**WEST SUSSEX COUNTY COUNCIL
LOCAL DEVELOPMENT SERVICES CONSULTATION**

SUBJECT: BR/110/08/ - Outline application for the redevelopment of premises to provide 14 no. apartments

18, Lennox Street, Bognor Regis, West Sussex

Ground Floor 2 N° Apartments

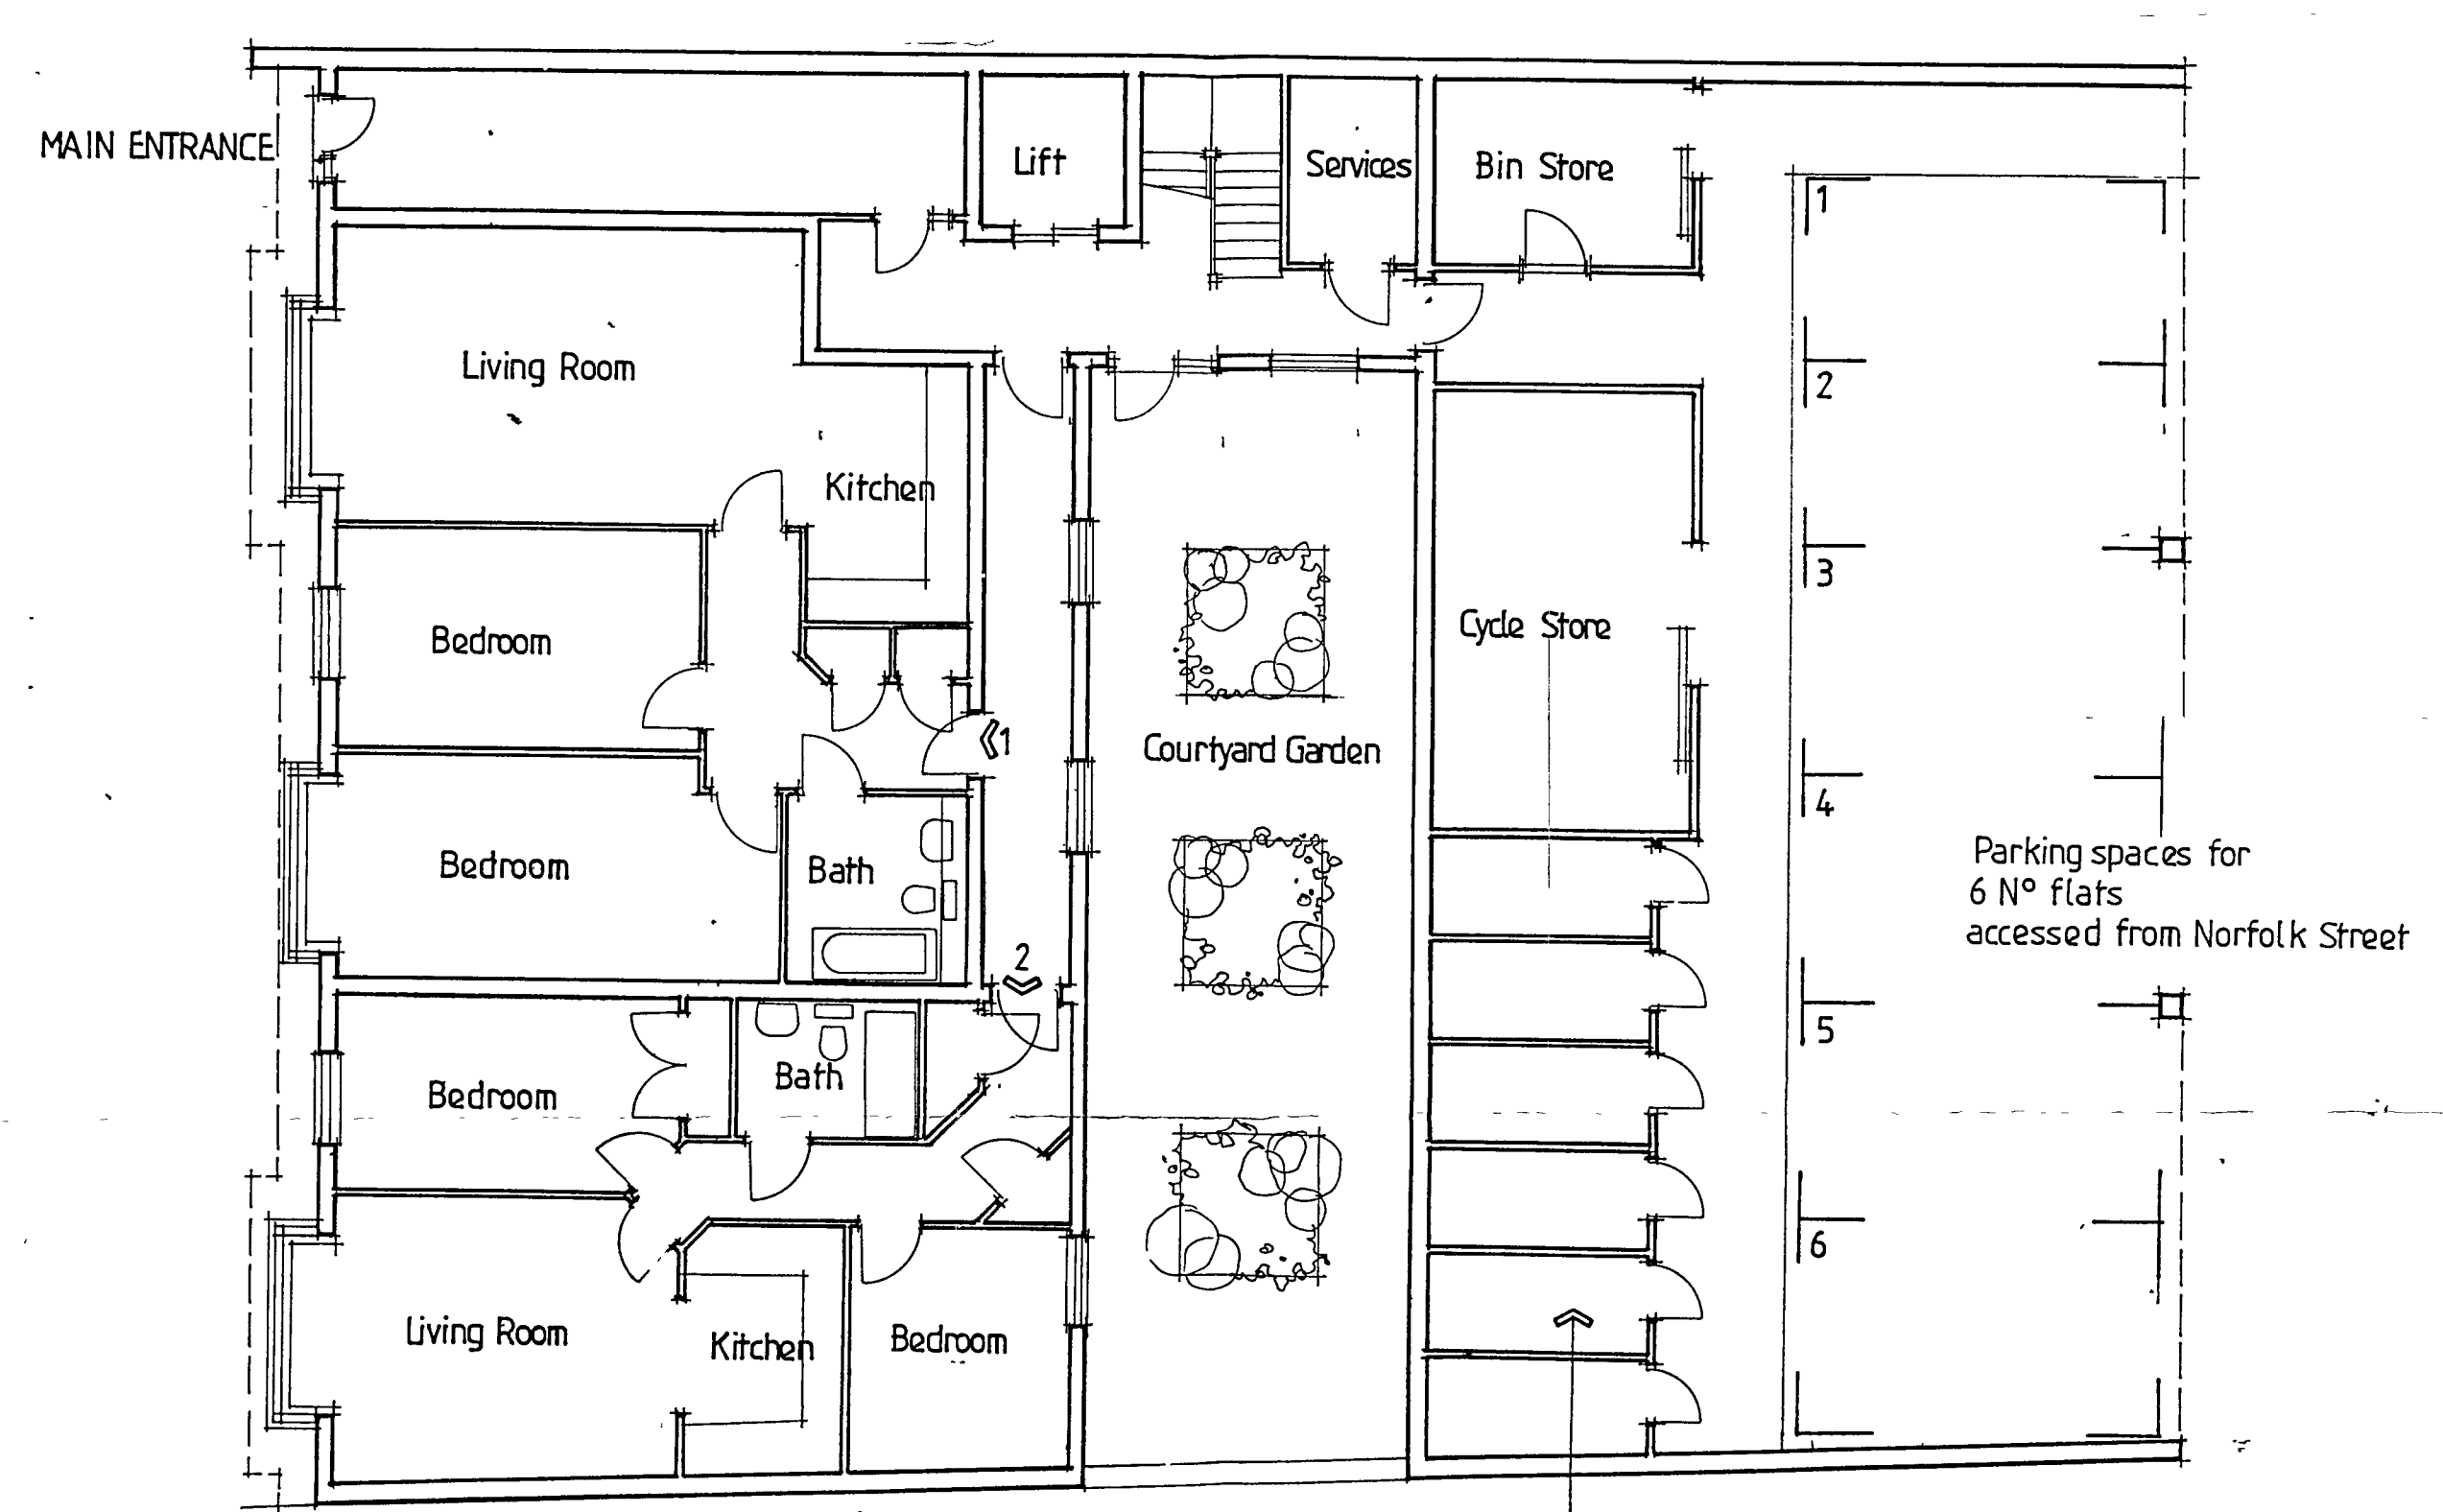
The highway implications of this proposal have been considered in part during the review of the approved BR/202/07, which was for 12 apartments above the existing garage site. The current proposal includes the garage, increases the number of units and seeks to provide 6 car parking spaces. A plan showing the access arrangements (both existing and proposed) and parking layout would be requested. Conditions would then be requested to ensure any existing vehicular accesses that are not to be used are stopped up along with conditions to ensure any new accesses are provided in accordance with the plans.

In terms of parking, the proposed parking is within the WSCC maximum parking standard and it is not considered that this proposal would result in any highway safety implications as a direct result of the low parking standards. Whilst on-street parking is restricted in this location, considering that the approved application was permitted without car parking, then current proposal does seek to provide a limited number of spaces. The site is situated within close walking distance of passenger transport facilities and a wide range of facilities, the location of the site therefore should encourage less dependence upon the use of the private car, in accordance with policy DEV4 of the WSCC Structure Plan. It would be preferable for cycle parking to be provided, although it is appreciated given the limited site area that this may not be possible.

Subject to confirmation over the parking and access arrangements from Norfolk Street and the securing of the S106 contributions, no objection would be raised.
